Our Ref: 23/04155/HFUL
Your Ref: The Cedars

**South Cambridgeshire District Council
Application for Planning Permission**

Proposal: Part single storey, part two storey rear extension and installation of sky lights to side elevation.

Site address: The Cedars Haverhill Road Castle Camps Cambridgeshire

THE CEDARS HAVERHILL ROAD CASTLE CAMPS CAMBRIDGE CB21 4TB	
2 STOREY REAR EXTENSION	
ELEVATIONS AS PROPOSED	
SCALE 1:100 @ A3	REV
DRAWING NUMBER 6

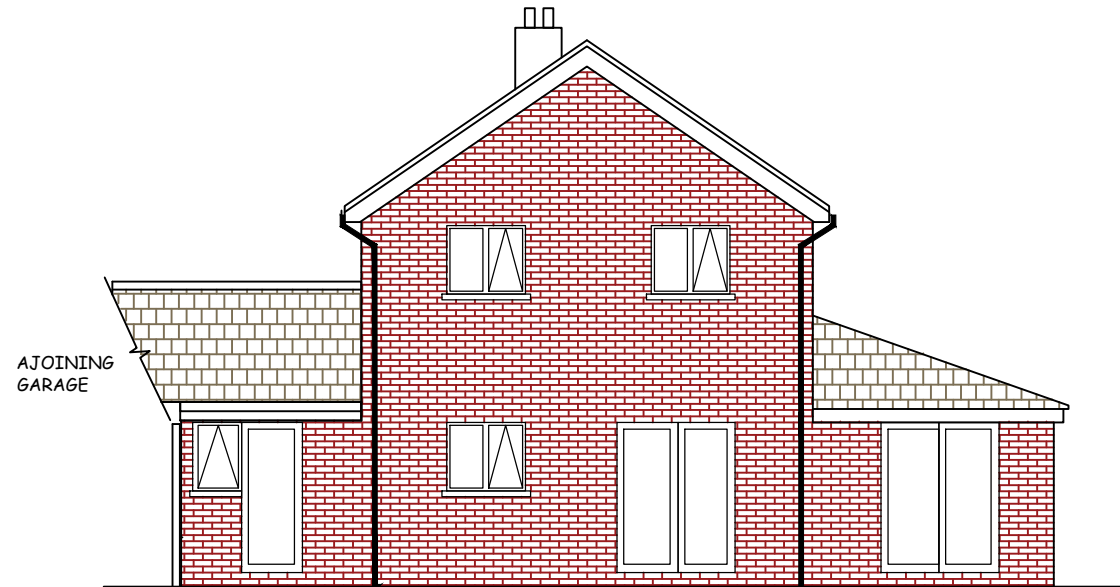
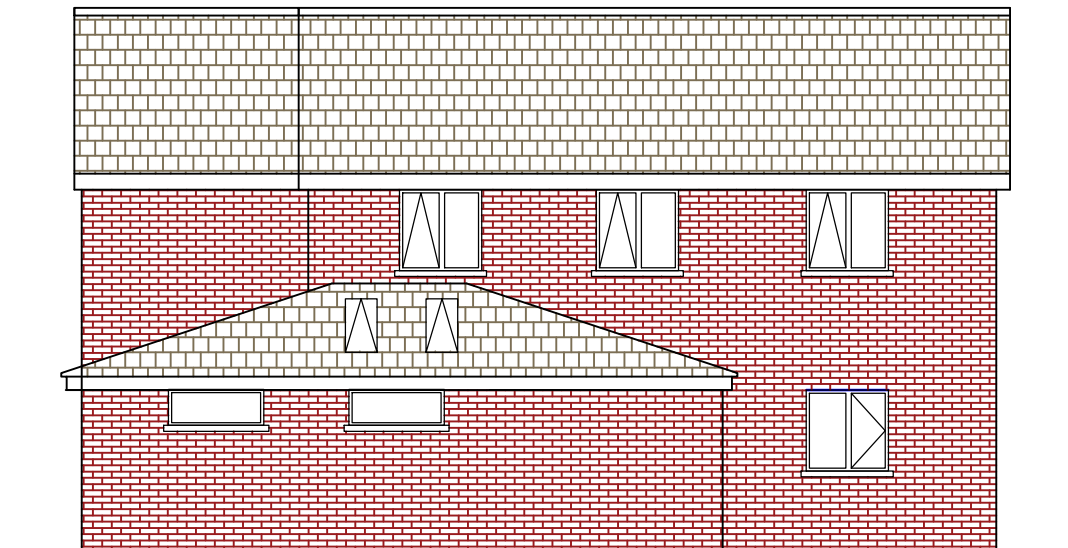
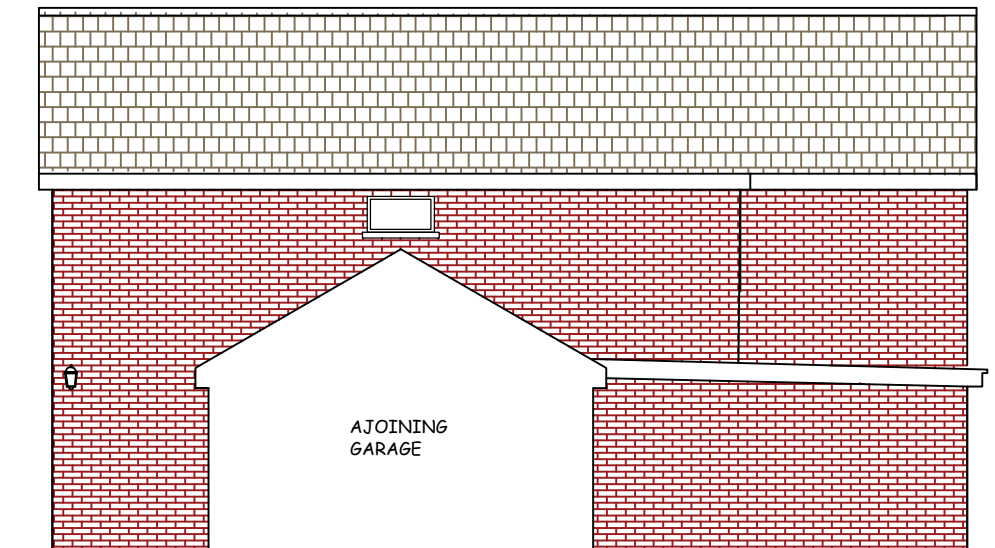
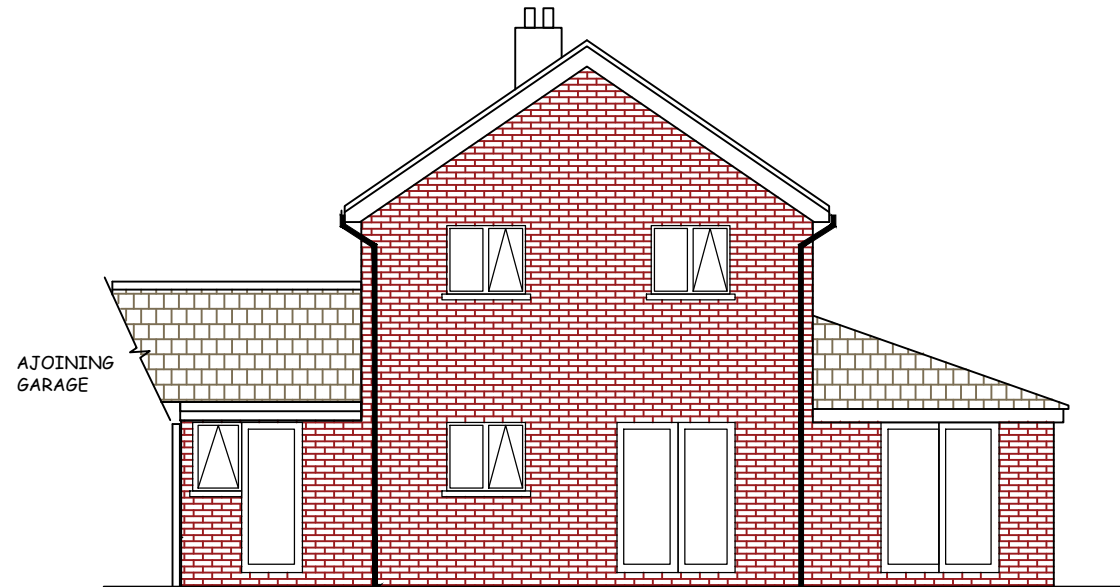
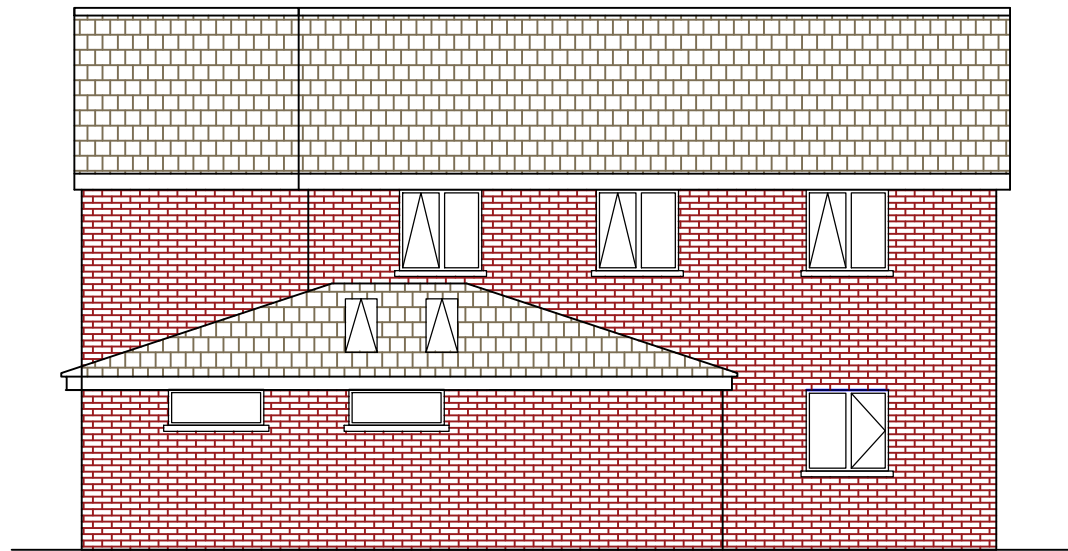
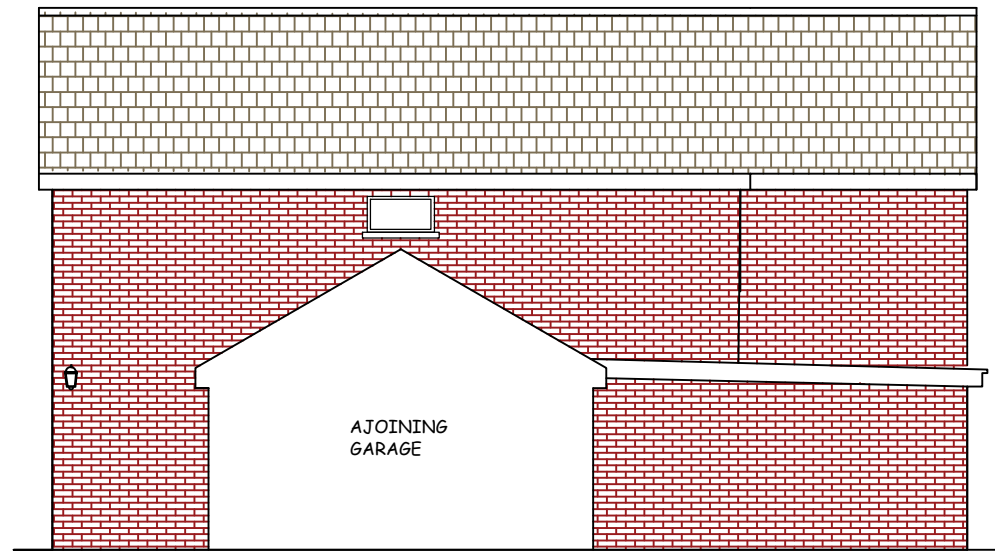
1. Drawing number 6 - Proposed elevations labels the elevations as existing. Please revise and re-submit.
2. Please confirm that you are agreeable to the proposal being amended to: 'Part single storey, part two storey rear extension and installation of sky lights to side elevation'.
